Afra Construction, on behalf of West Mesa RV Park formerly known as Paradise RV Park, request Final Sign Off for Site Development Plan approved by EPC

REFERENCE: WEST MESA PARK – FORMERLY KNOW AS PARADISE RV PARK

PROJECT NO: 1008330 / EPC -40073 PHASE II. AND PROJECT NUMBER PR-2024-010907- DFT APPLICATION NUMBER SI-2024-01331.

SP-3
MARCH / 2024

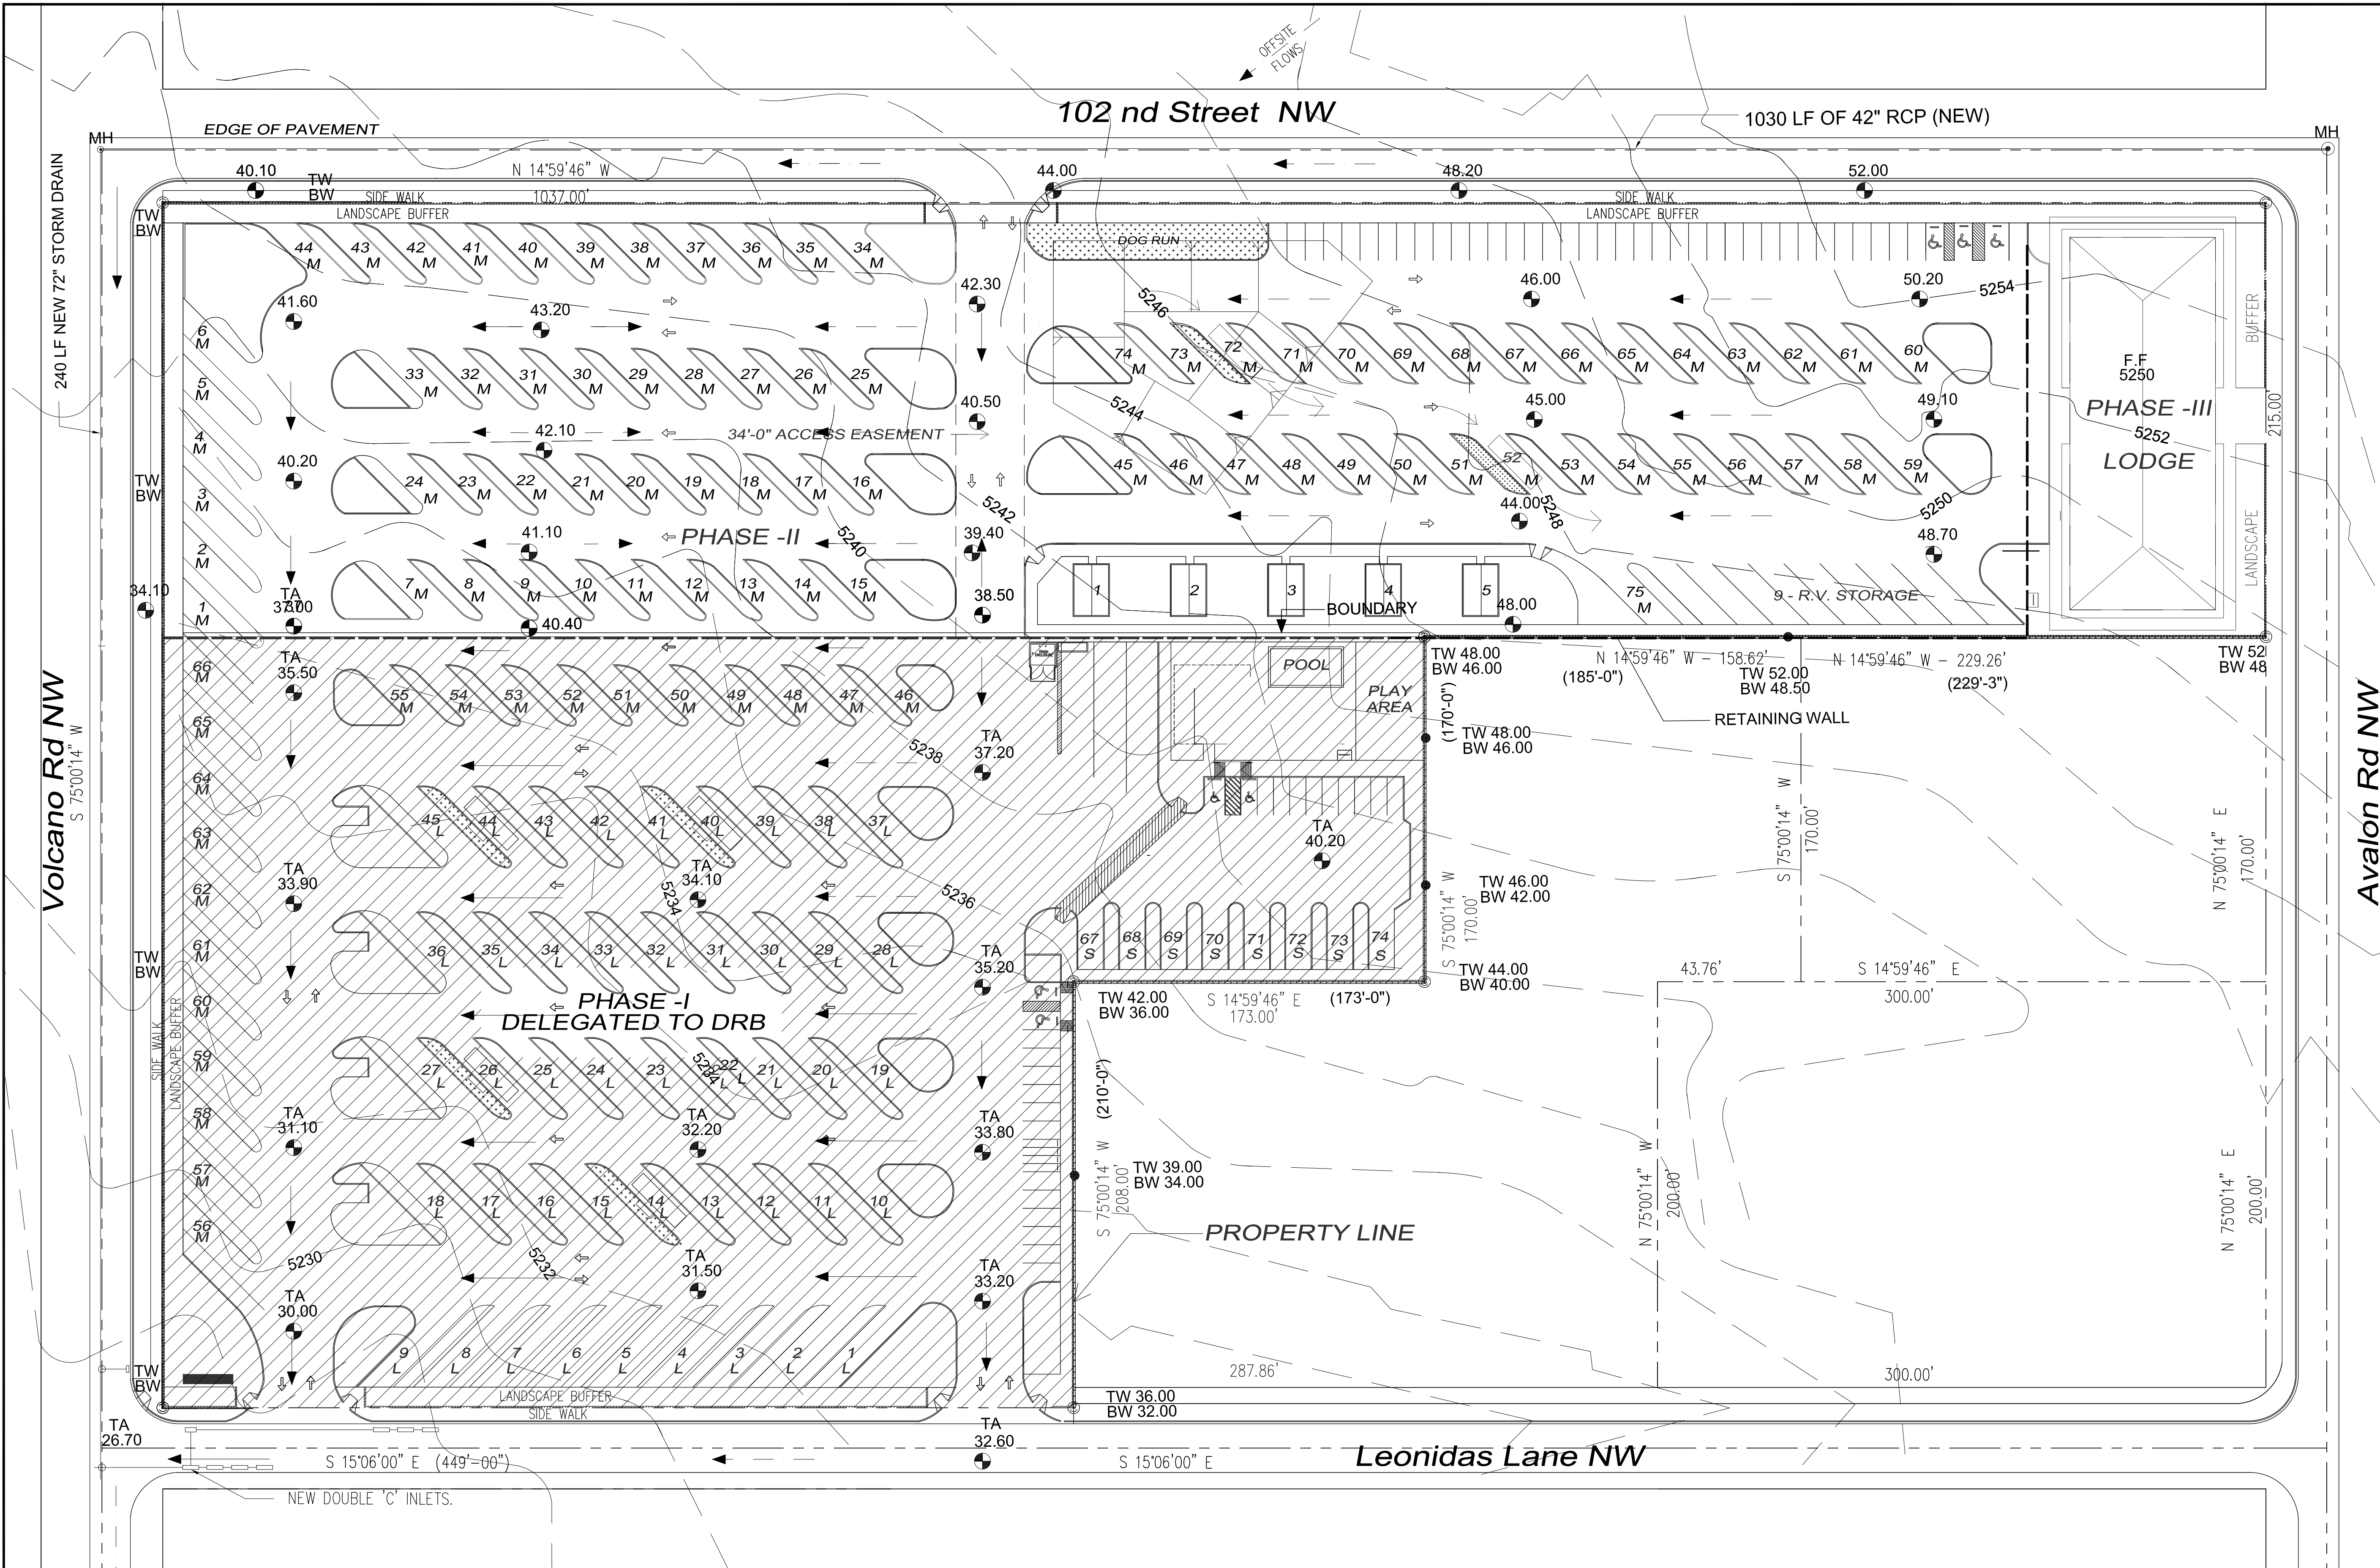
3. The motorcycle and one-way signage shall be shown on the detail sheet.

7. The site plan shall have a note stating whether the two pole-mounted signs have one face or two.

**Please refer to sheet no SP-3 – Note No 14 “MOTOR CYCLE PARKING SIGN”.**

**The two pole mounted Sign shall be Double Faced as shown on Sheet SP-3.**

C-03

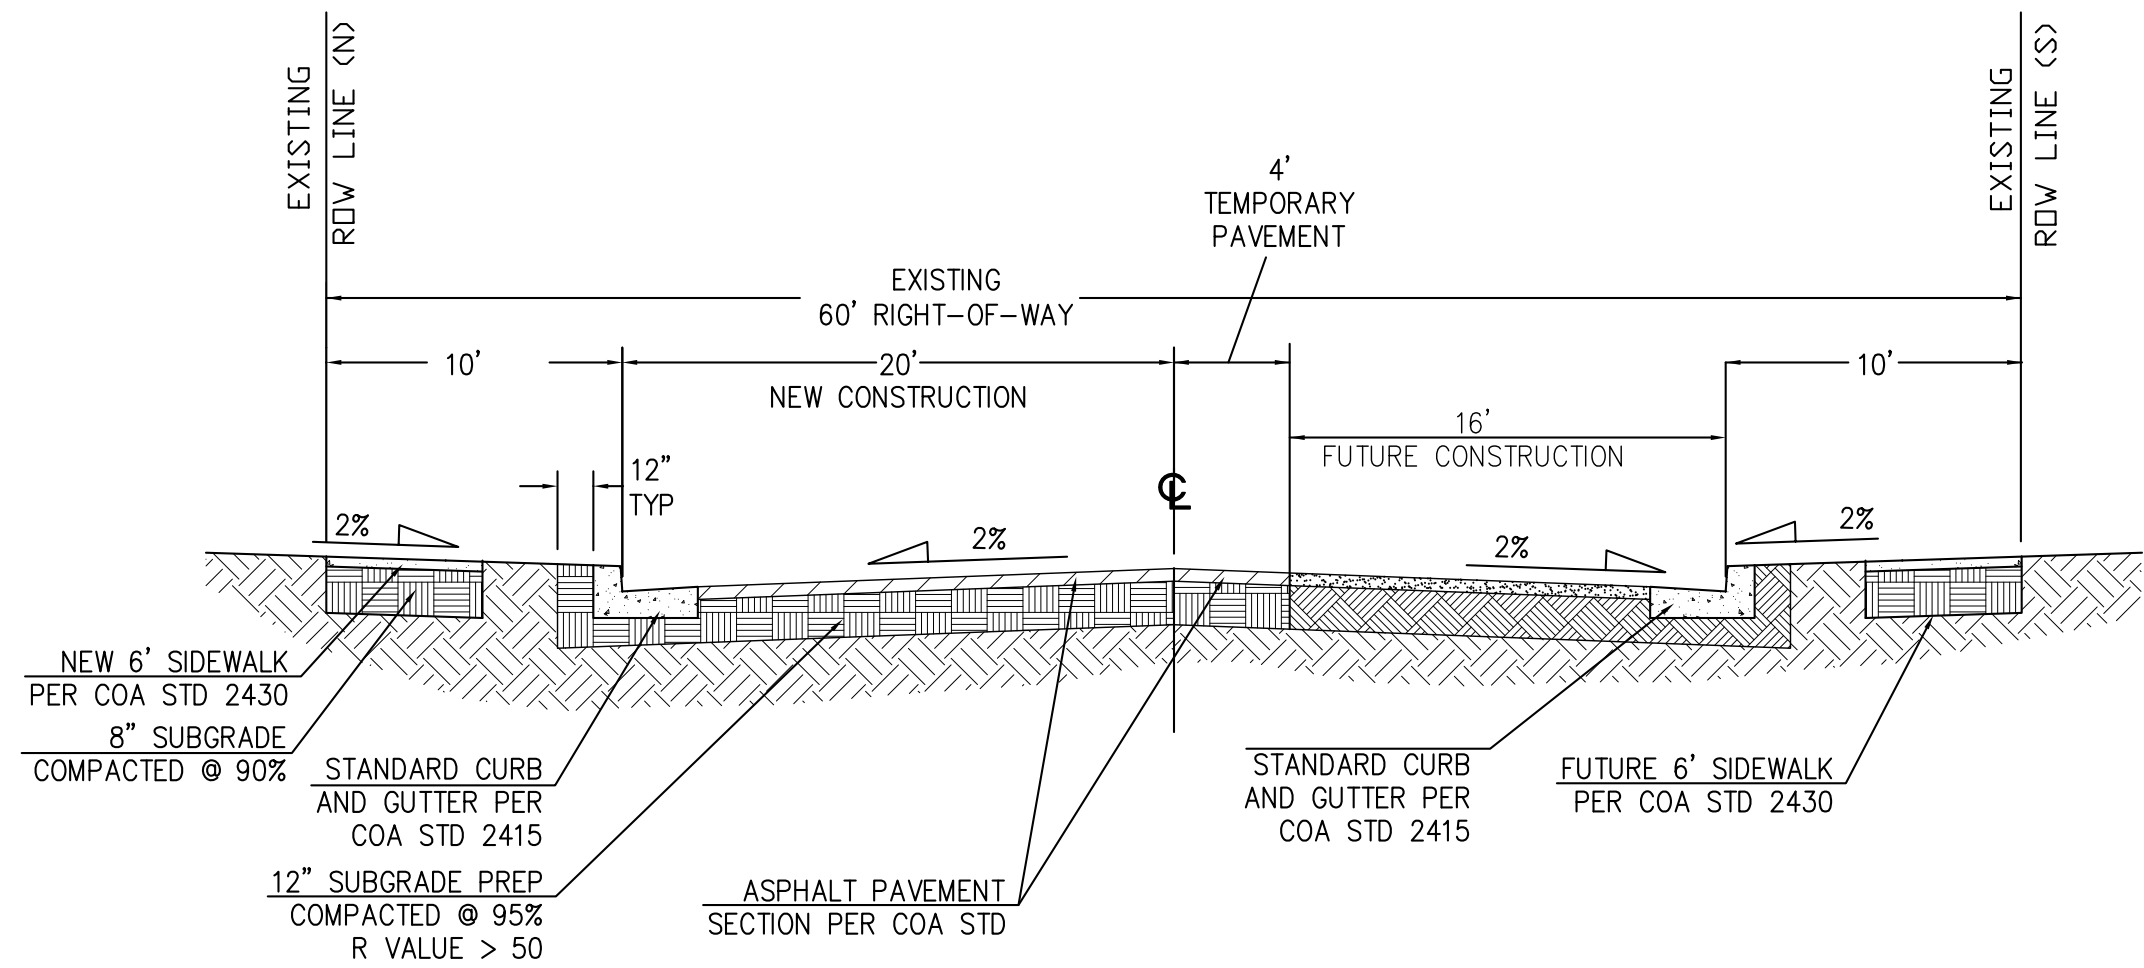
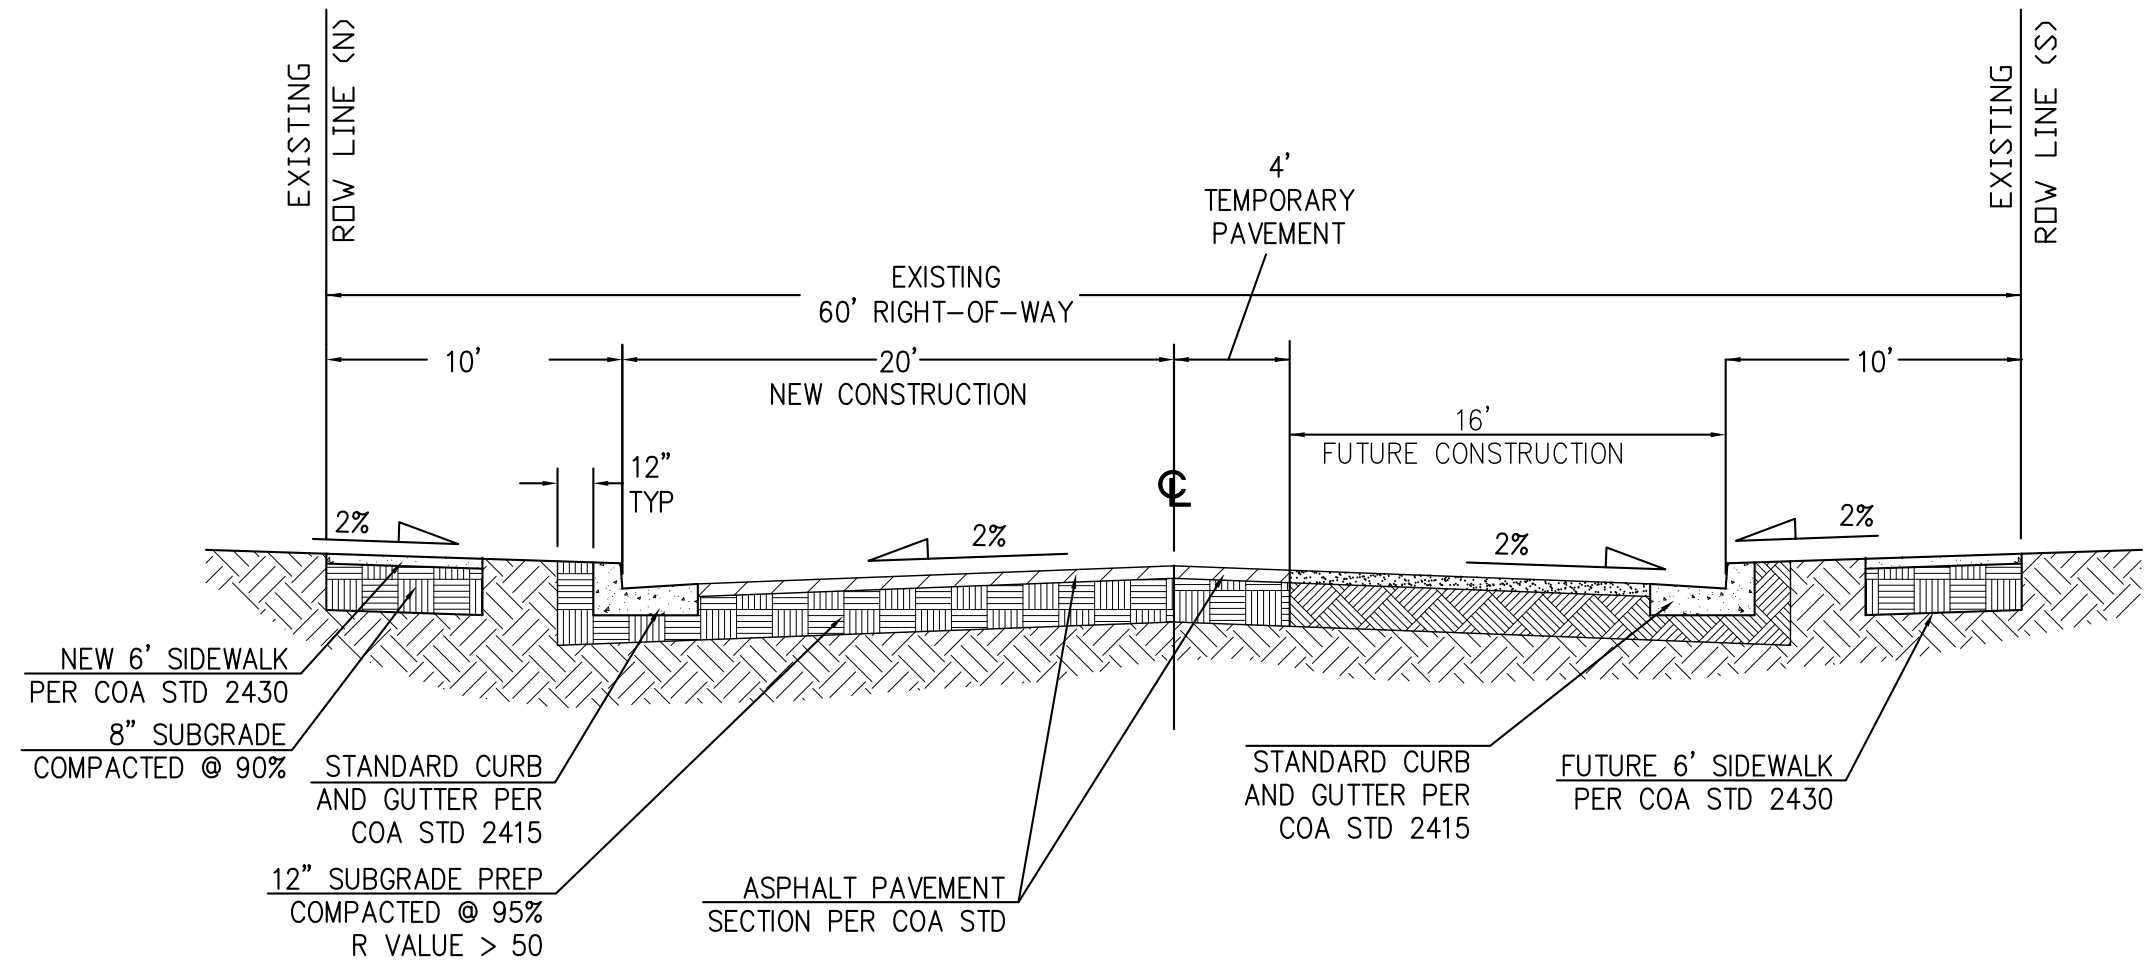
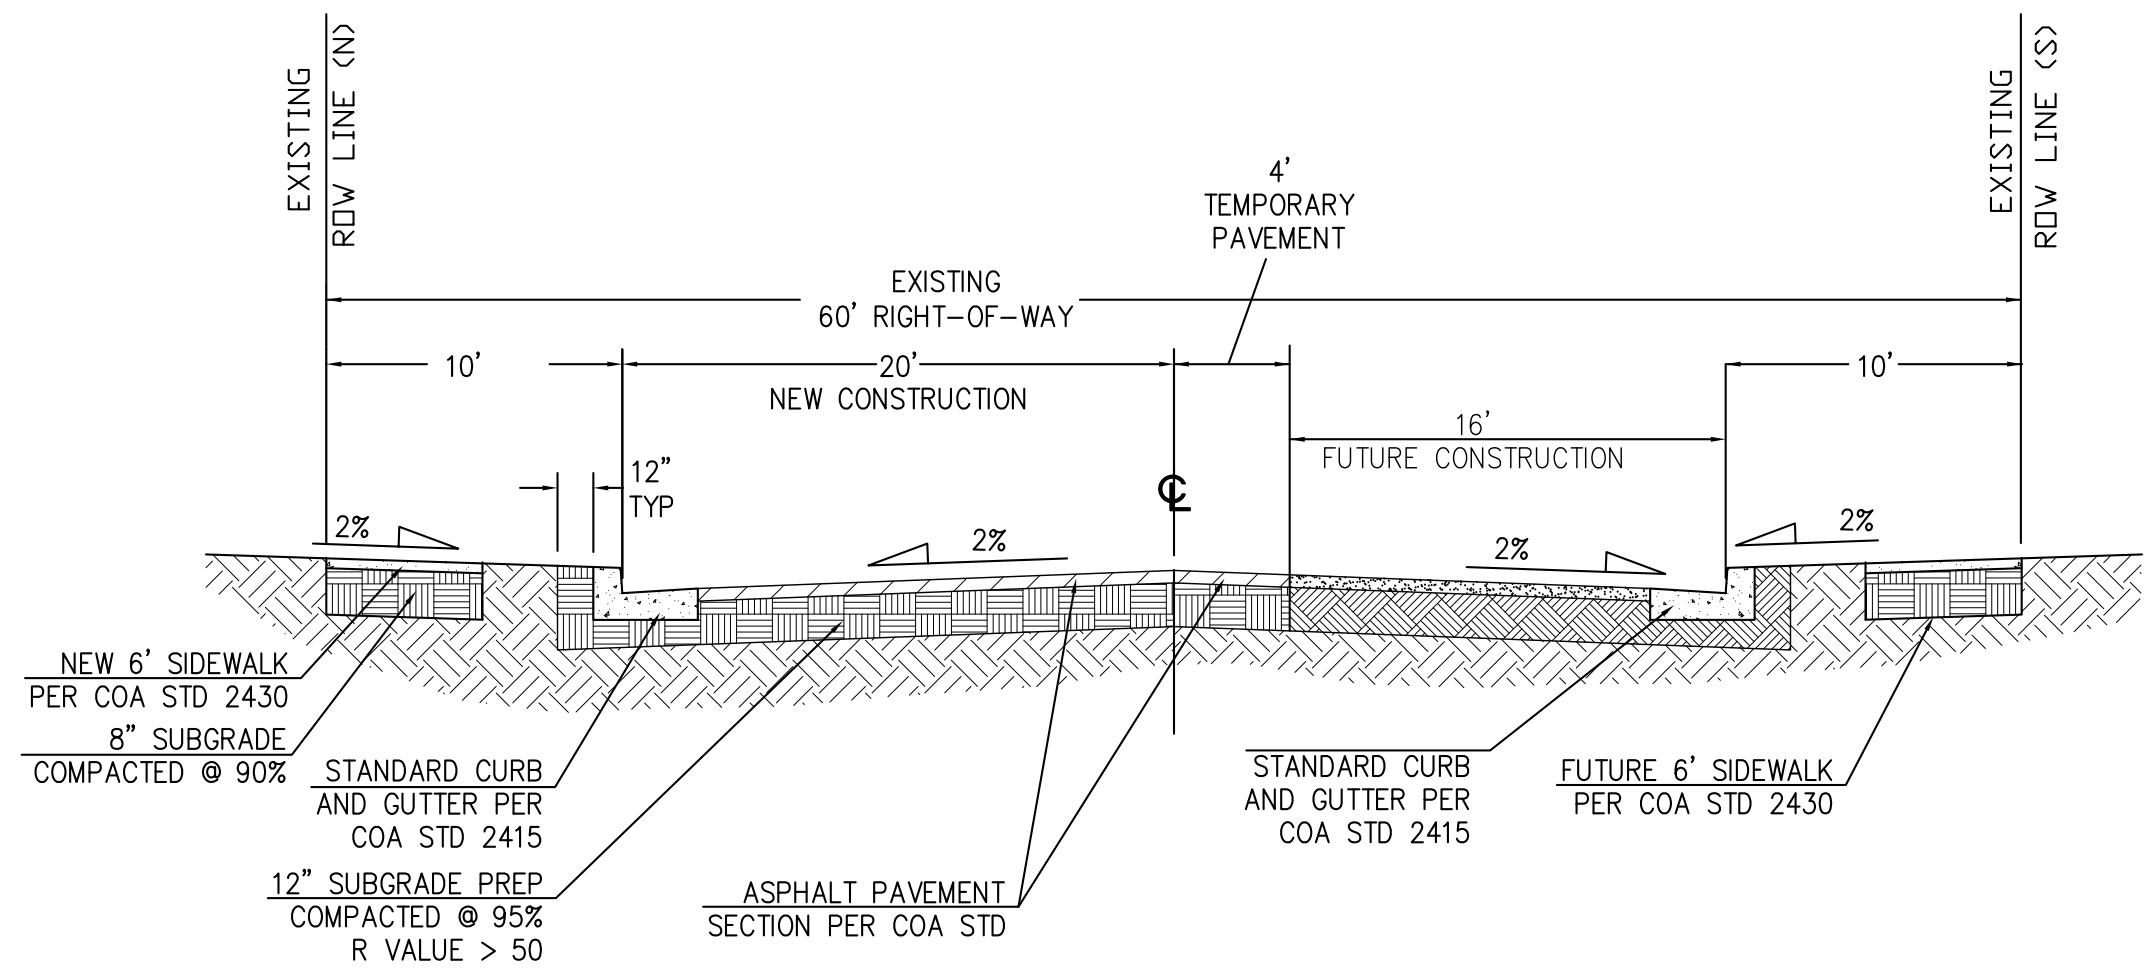
- f. Please clarify the limits of all paving.

**All Limit of Pavements for Volcano, Avalon and 102<sup>nd</sup> Street are shown on the Typical Cross Section Sheet C-03**
